Subject: Exhibition of 7 Railway Street, Chatswood (MP09_0154)

SCHEDULE 1 – KEY ISSUES

SCHEDULE 2 – ADDITIONAL INFORMATION REQUIRED / COMMENTS

title:
Proposed Residential Scheme
 Shadow Diagrams
 June 21st 12pm

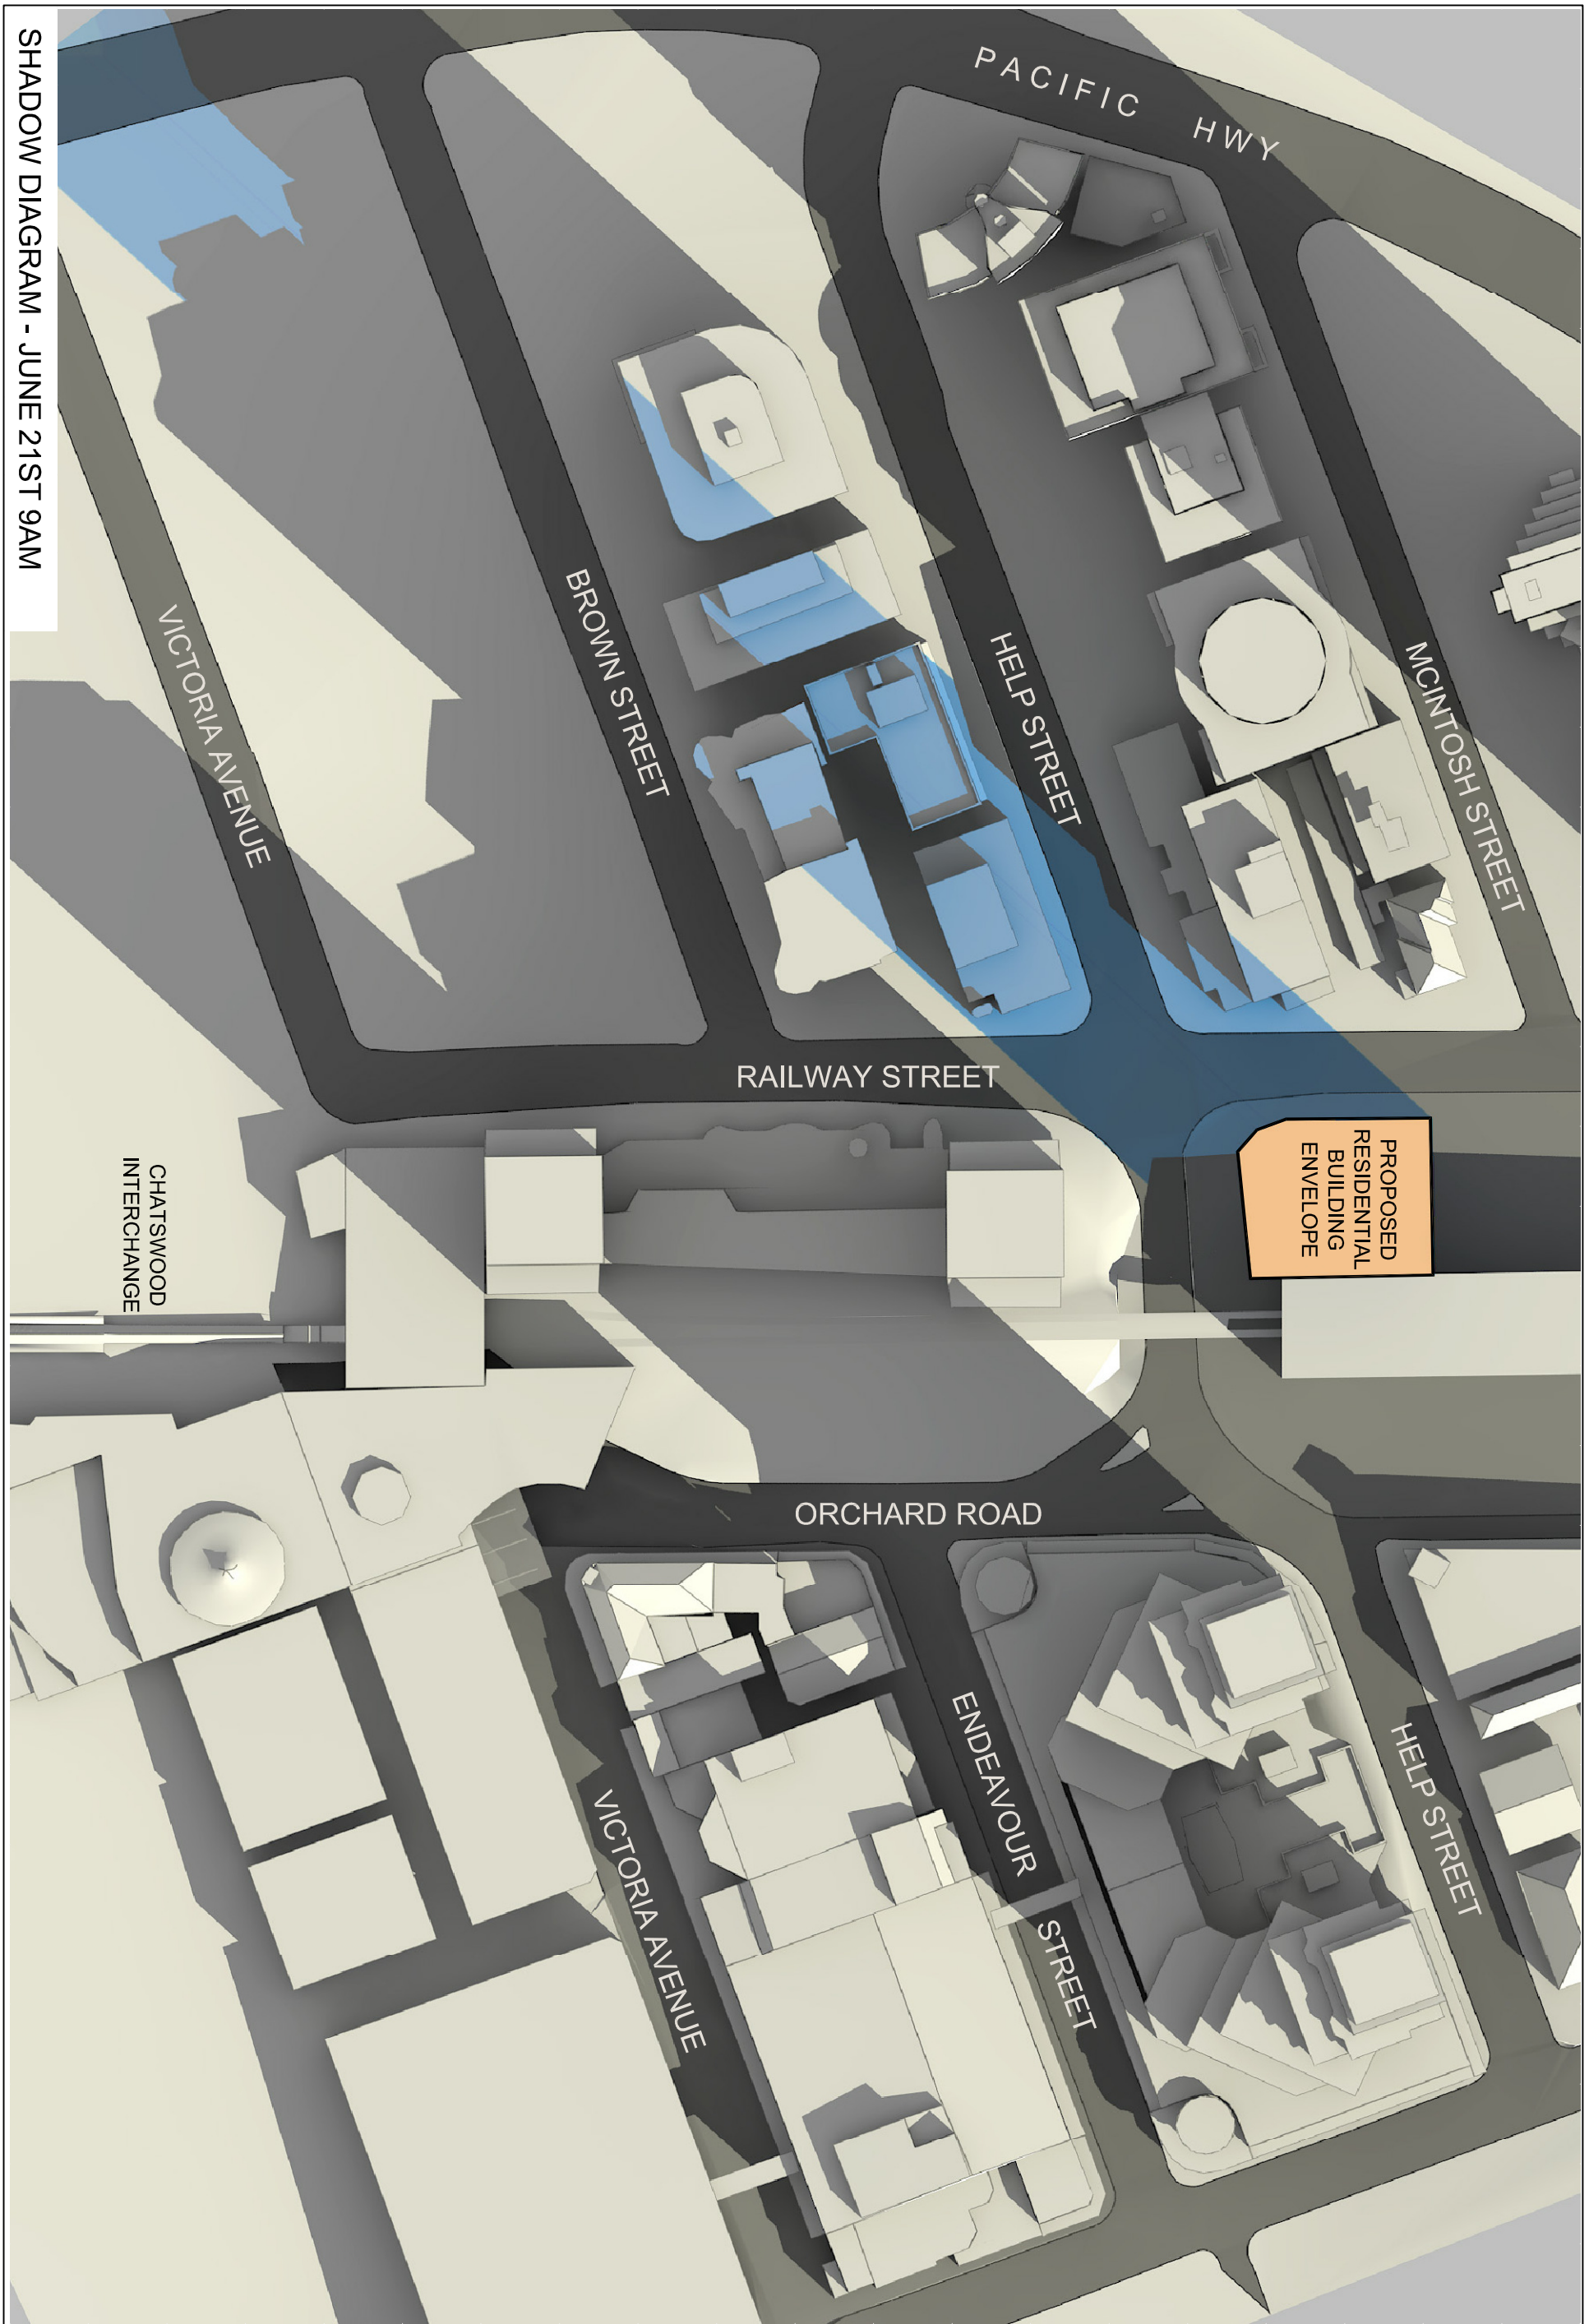
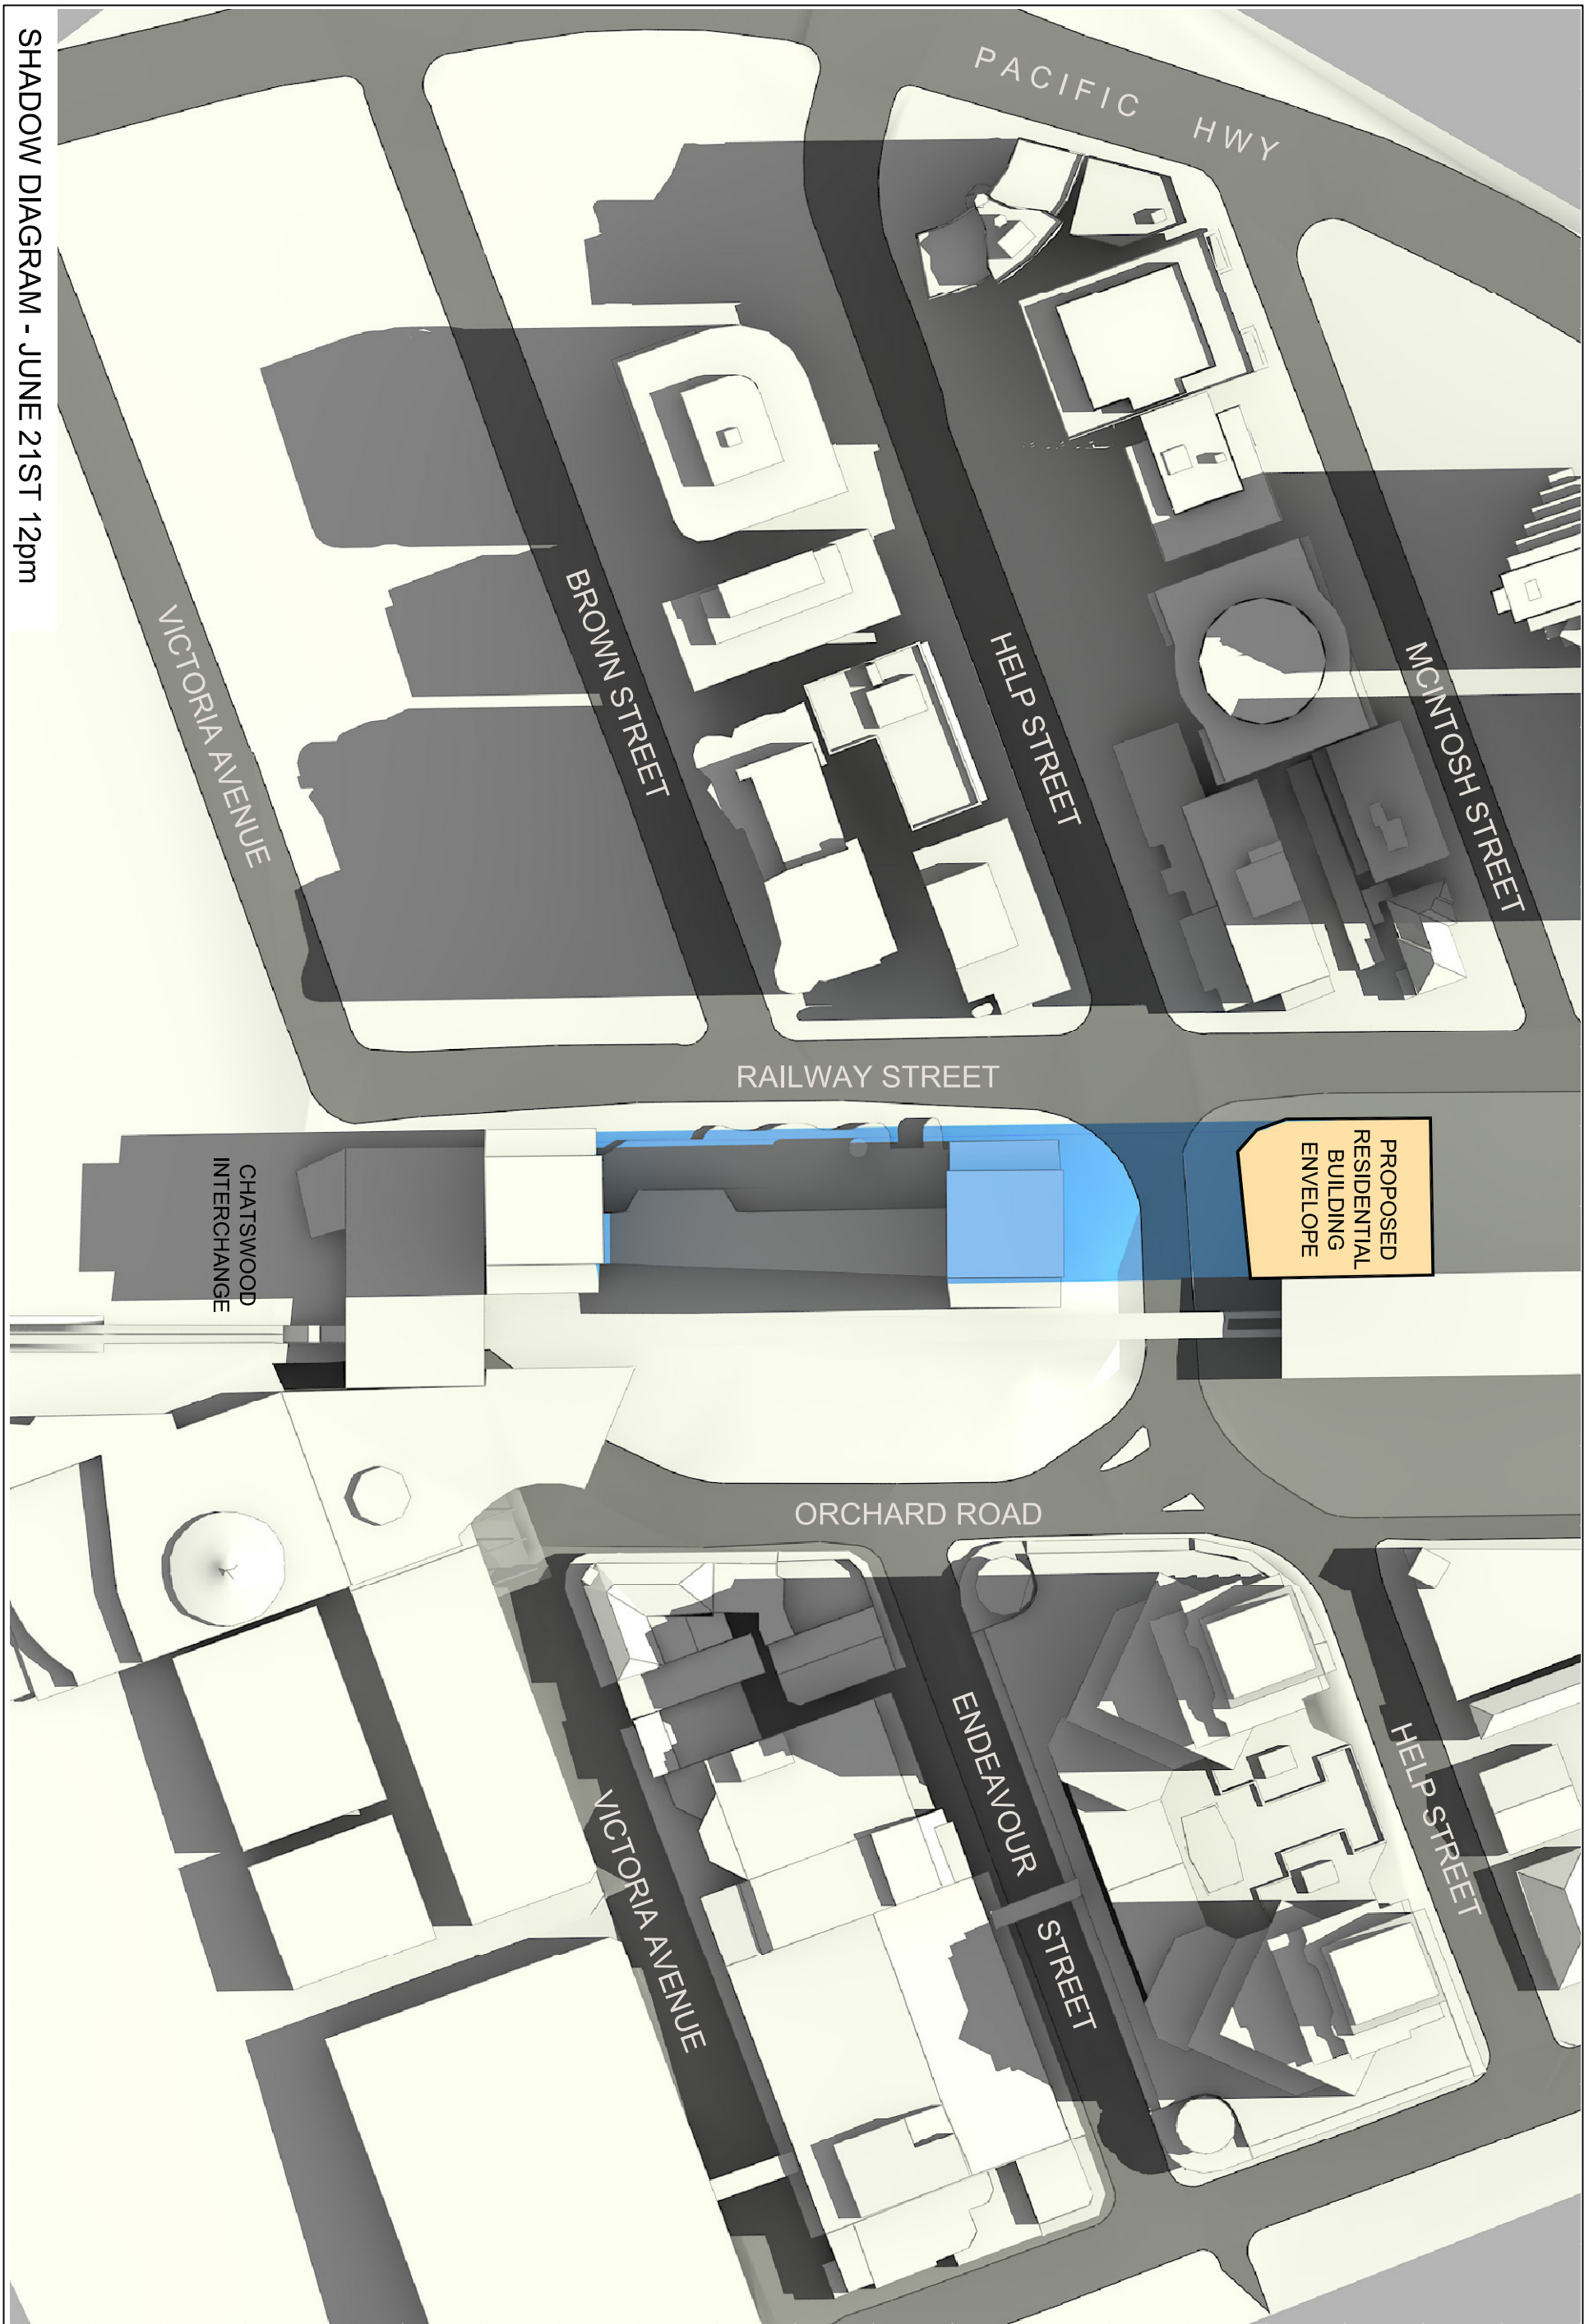
- A shadowing analysis detailing the shadow cast on the proposed building by neighbouring towers at 9am, 12noon and 3pm at 21 June should be provided to demonstrate that at least 70% of living rooms and balconies can achieve 2 hours solar access in accordance with the SEPP 65 Residential Flat Design Code.
- A response and/or additional plans to address Council's concern that the proposal will increase overshadowing of Chatswood Mall. The response should address the concern that the proposal *"lengthens the shadow cast considerably and, therefore, increases the height of the impact and the awareness of shadowing"*.
